Planning Officer: Ross Leal

Planning Application Ref: R/267/17/PL

Location: Rustington Hall Nursing Home, Station Road, Rustington

Description of works: 2 storey block of 6 No. Flats comprising of 4 No. 2 bed & 2 No. 1 bed flats.

Issue	Details	By	Date
SCALE	AS SHOWN on A4		
DATE	20/10/17		
DRAWING NUMBER	15072/01a

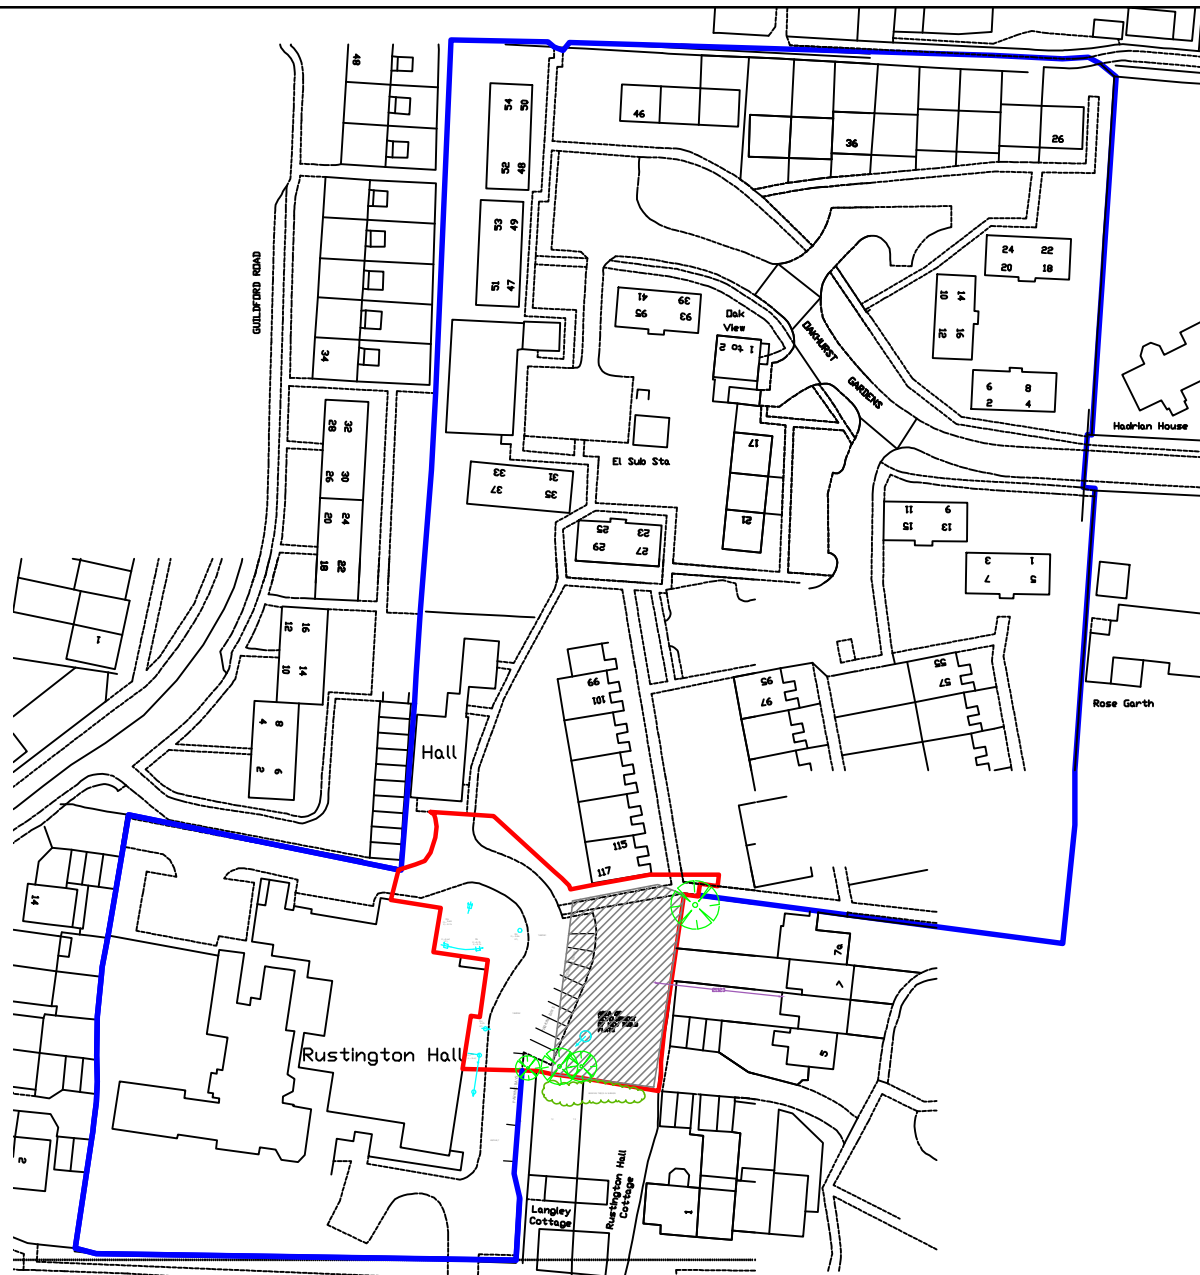
- No consideration has been given in the design layout to the protection of an off-site birch tree (rear garden of 7a Paddock Green), despite it being identified on the plan drawing 15072/01a and the most significant tree in proximity to the site in terms of amenity value.

- There is opportunity and so I would expect, a revised design layout to be submitted that does not involve any working within or interference of ground conditions immediately adjacent to the RPA of retained trees T1-Yew and birch (rear of 7a Paddock Green).
